Recommendation Report for Planning Permission for Works or Extension to a Dwelling

REF NO: FG/150/19/HH

LOCATION: 4 Downview Road
Ferring
BN12 6QR

PROPOSAL: Single storey side/rear extension and roof extension.

Kerb levels have been taken on the top of the channel.

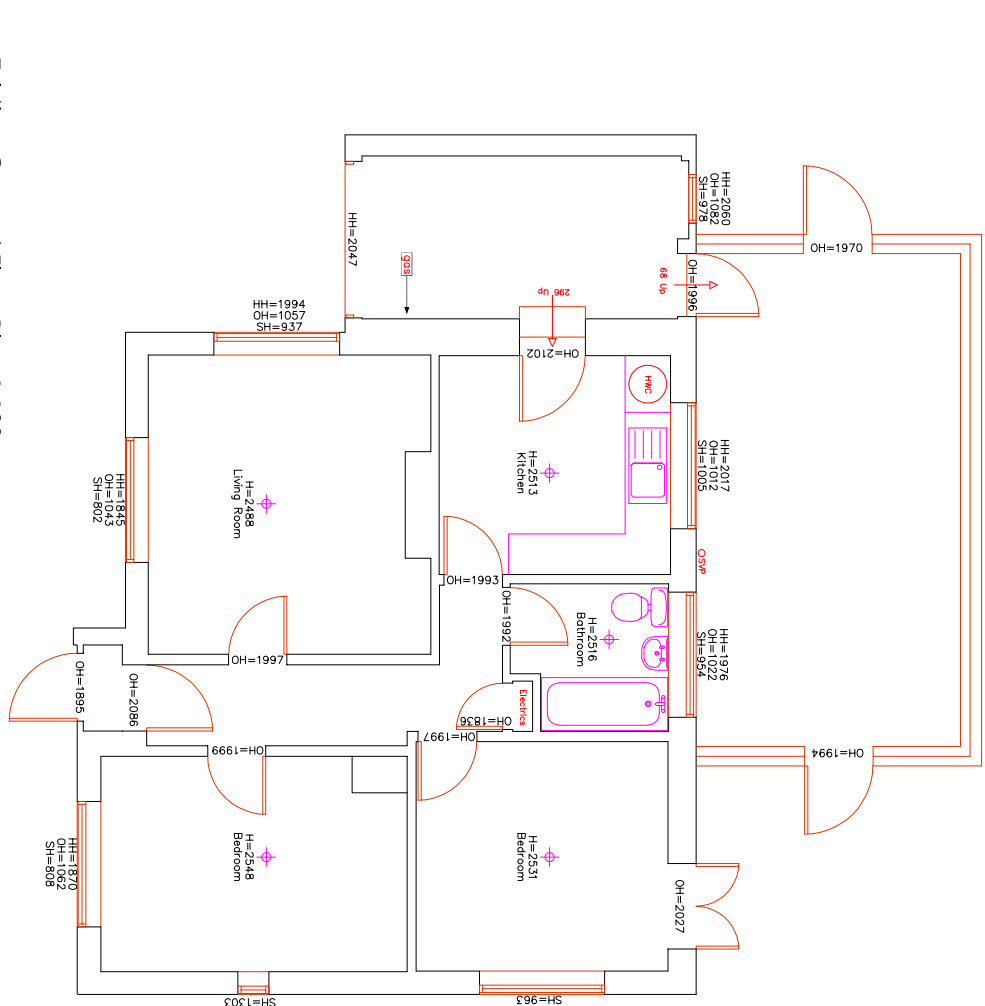
The proposed side and rear extension will be visible from the street scene, as it wraps around the Northern and Eastern elevations of the host dwelling. Therefore, there will be views of the Northern element of the proposal from the public realm. These additions are significant, and will alter the appearance of the property. However, due to it being set back approximately 10m from the street scene, it is considered to have a reduced impact upon the character of the locality.

The proposed roof extensions are considered to be acceptable additions to the host dwelling. The rear element of the proposal is considered to be a sympathetic, and well integrated addition to the host dwelling, as it matches the ridge height, eaves height and the roof slope angle of the existing dwellings roof. The proposed Northern dormer is considered to be subservient in appearance to the host dwelling, resultant of its scale, and siting on this roof slope. Furthermore, there are examples of similar proposals within the locality.

The proposed development is not considered to result in any significantly harmful impact upon the residential amenities of neighbouring dwellings. This is primarily due to the siting of the proposed extensions and the boundary treatment allowing for no significantly harmful overshadowing of the adjacent dwelling to the North. With regard to potential for overlooking, the proposed development is not considered to result in any harmful overlooking of adjacent occupiers, in that any proposed windows are either at ground floor level, or will be conditioned to be retained as obscure glazed in perpetuity.

Reason: For the avoidance of doubt and in the interests of amenity and the environment in accordance with policy D DM1 of the Arun Local Plan.
- 3 The windows at first floor level, on the Northern elevation of the proposed dormer shall at all times be glazed with obscured glass and, with the exception of any part of the window 1.7m above floor level, be fixed to be permanently non-opening, in perpetuity.
